DEPARTMENT OF PLANNING

SUBJECT: COLLEGE OF FINE ARTS MP08 0104 MOD 2

To determine a modification request for the College of Fine Arts Campus (COFA), Paddington, Project Application (MP 08_0104)

project	COFA Gateway
drawing	SITE PLAN WITH SHADOW DIAGRAMS
drawing no.	issue
A0-02	C

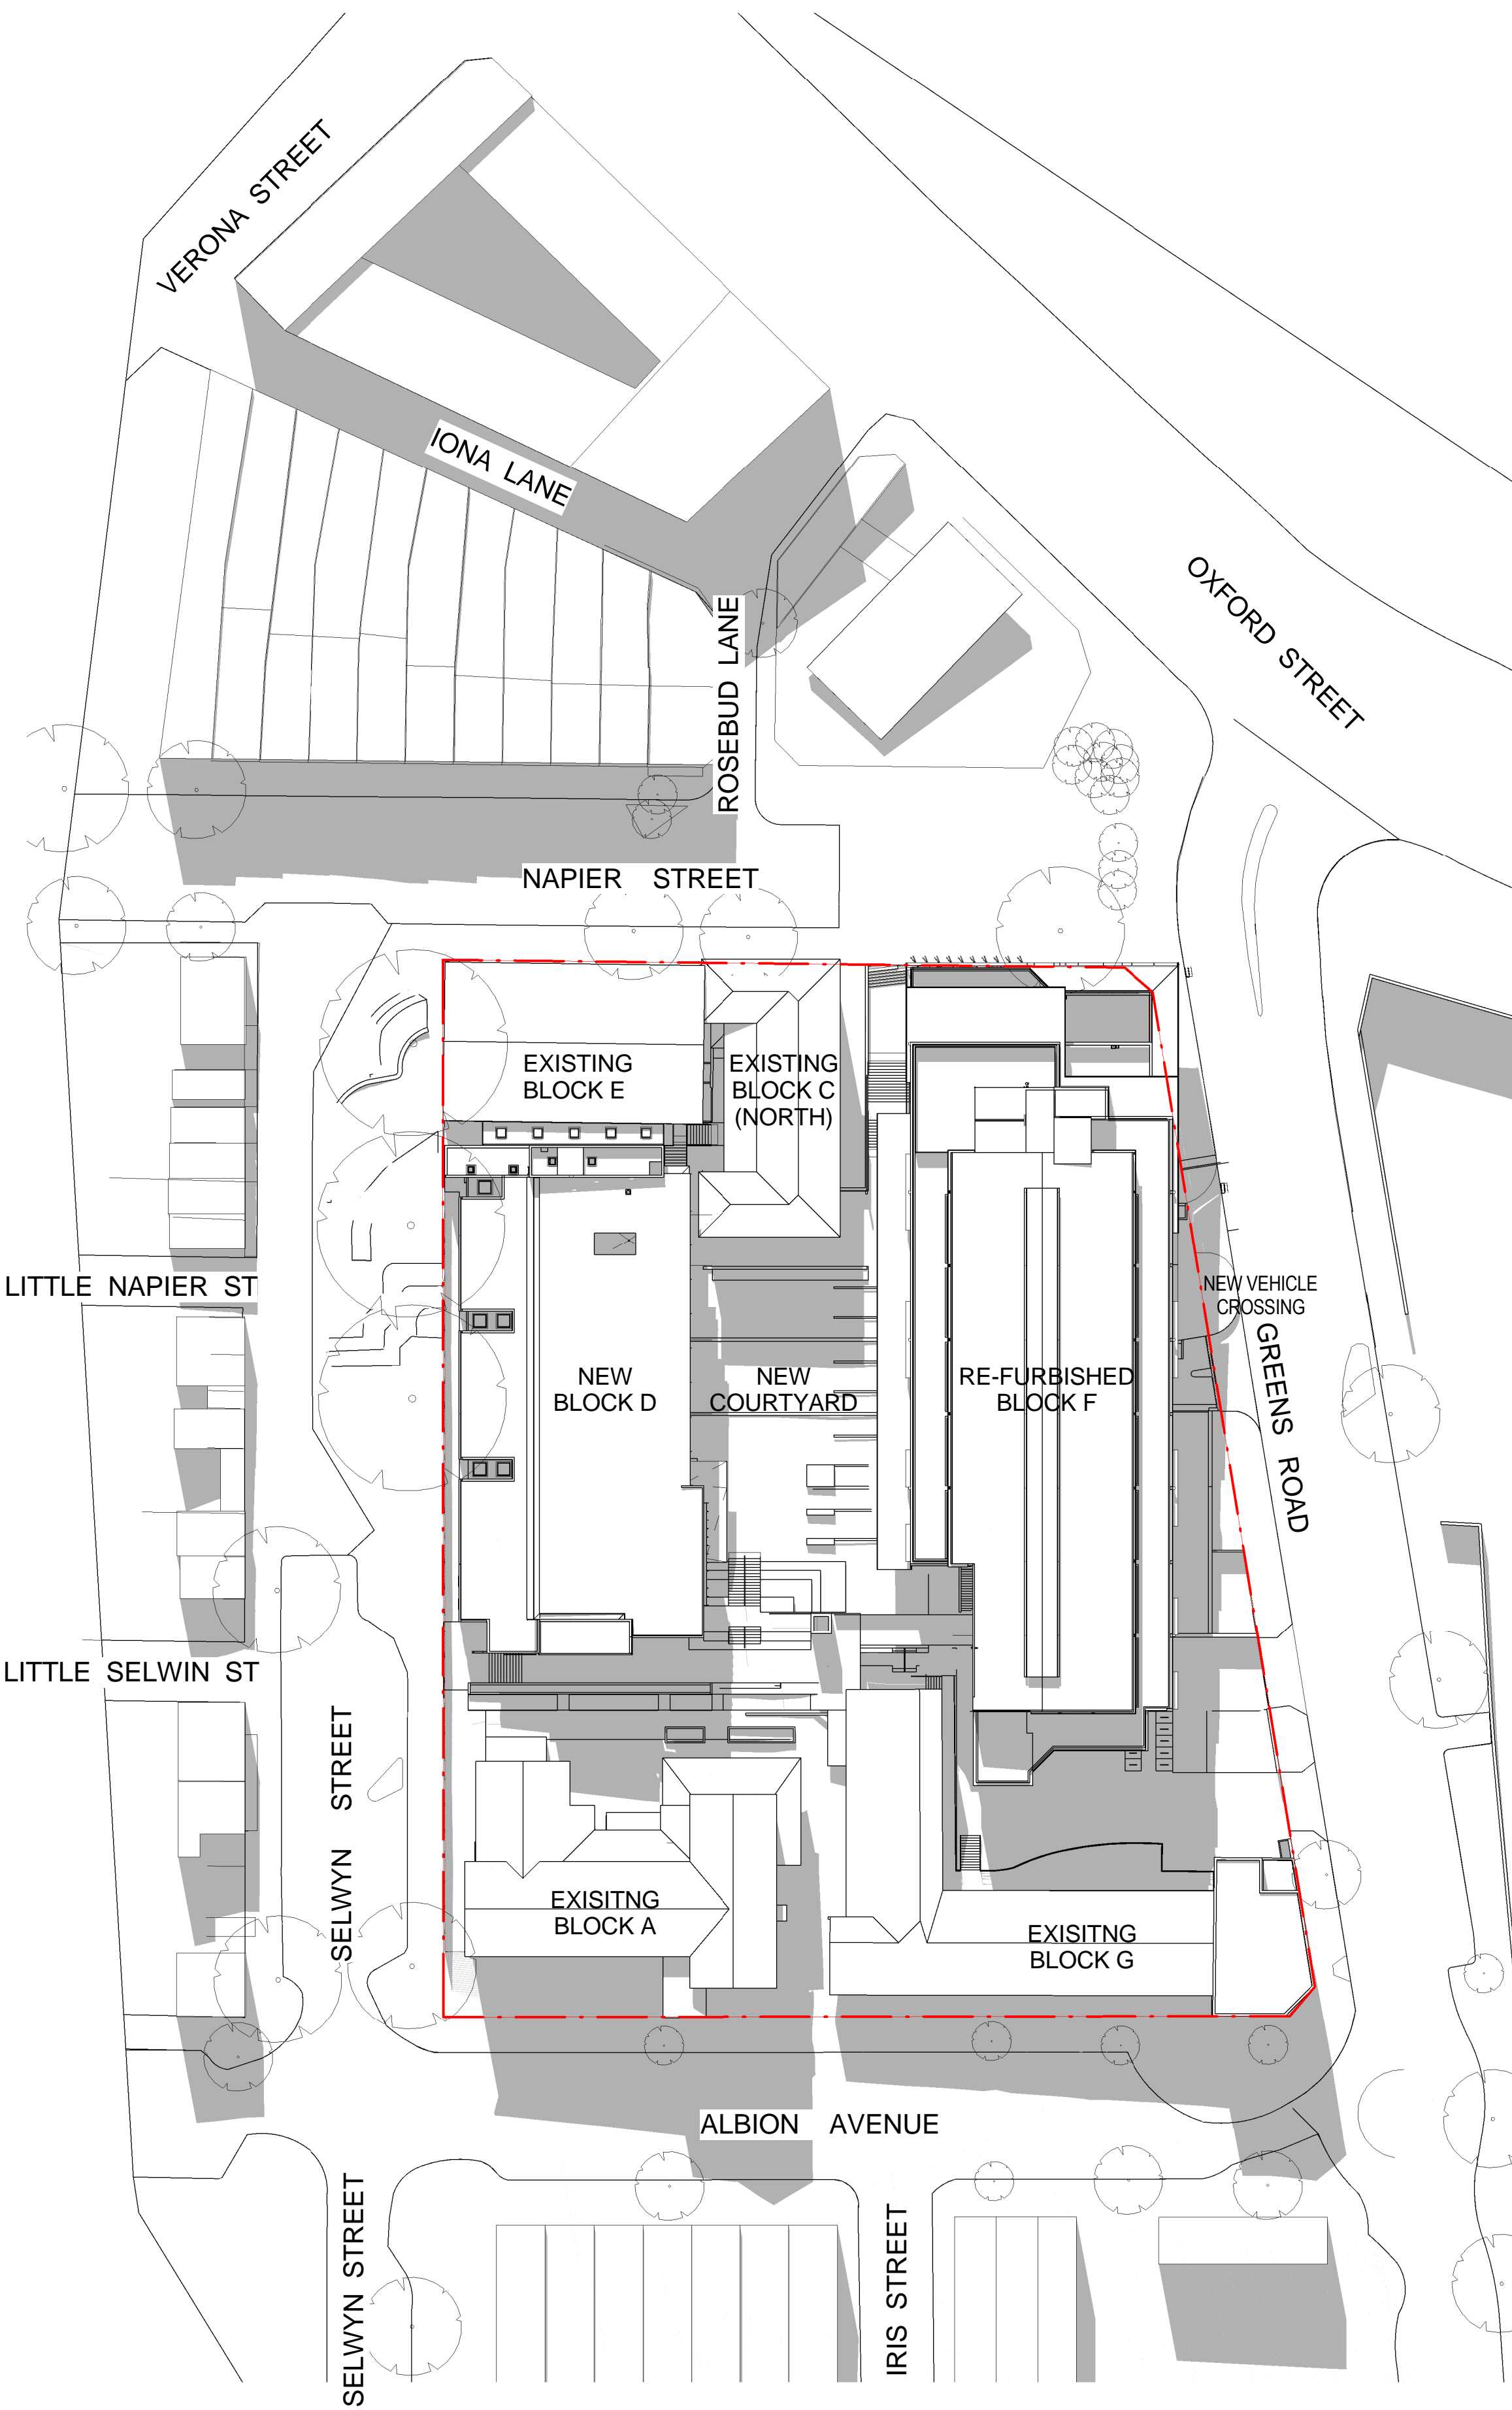
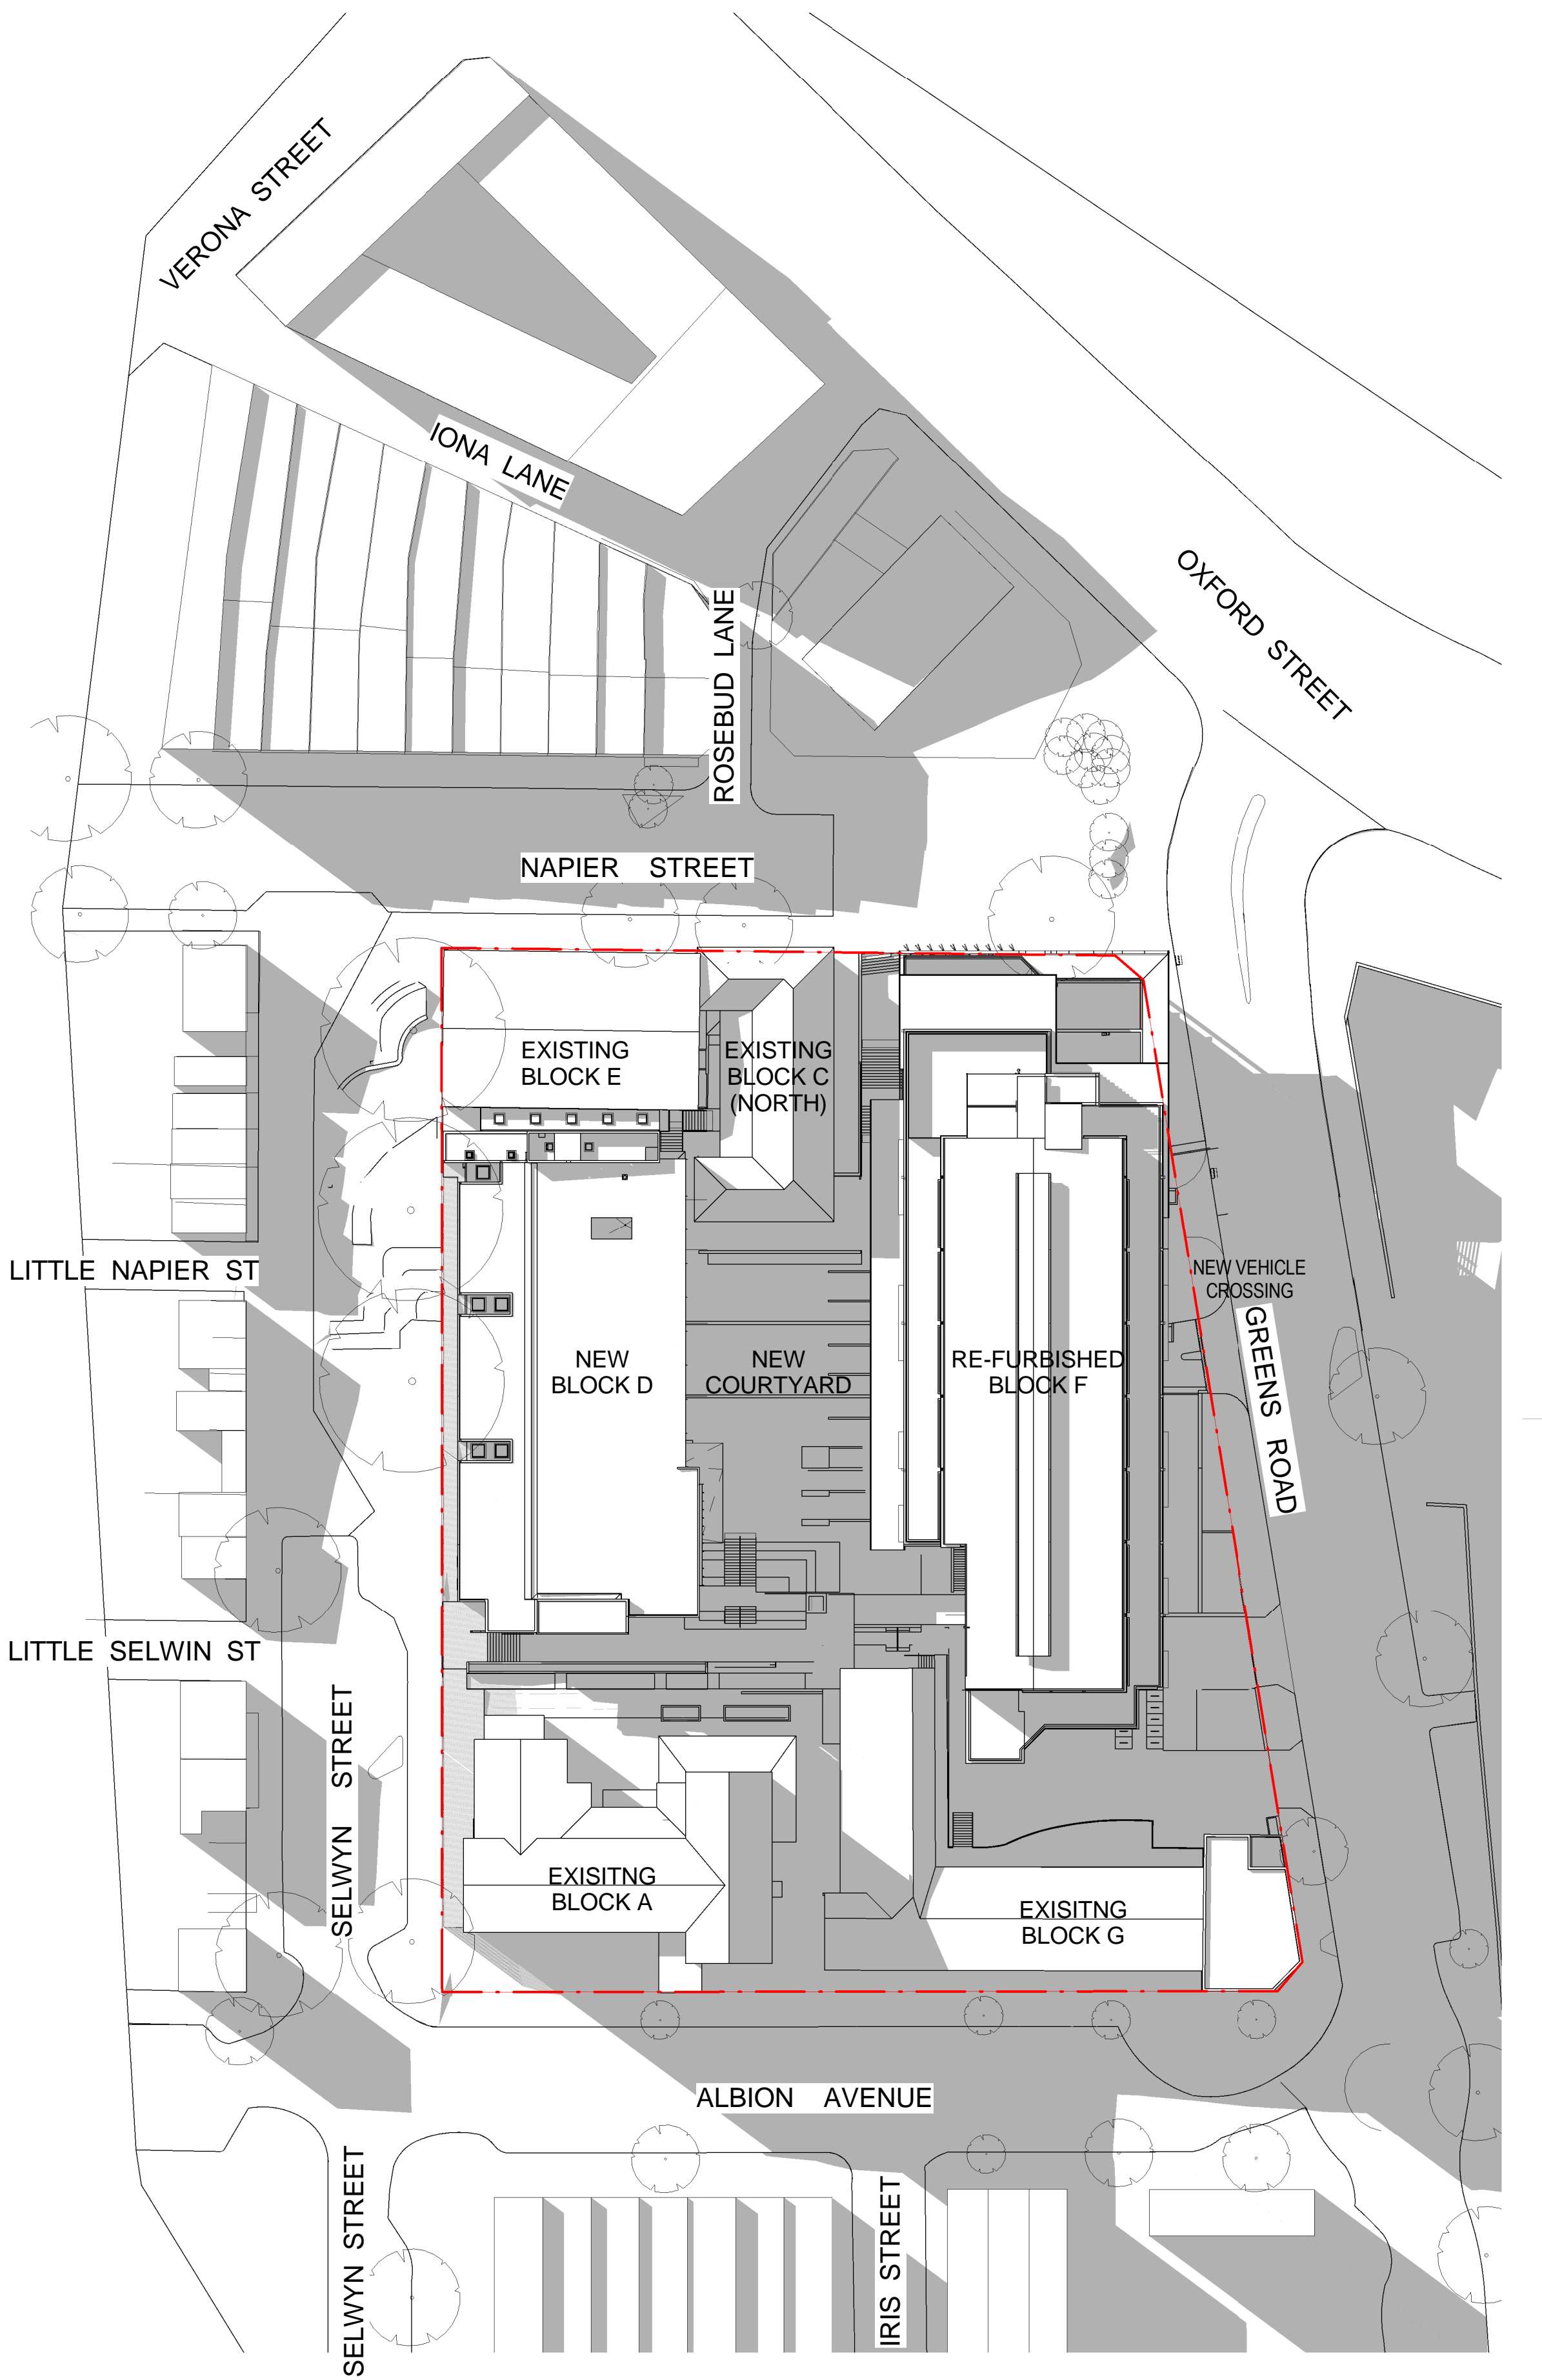
Setting the building back from the boundary will both further protect the existing street trees and decrease the shadow impact in Selwyn Street. This provides more setback than that provided for in the DCP. The marginal (400mm) increase above the height limit of the two lift cores at either end of the building does not increase overshadowing in Selwyn Street, nor create any other adverse impacts on the site or surrounding environment.
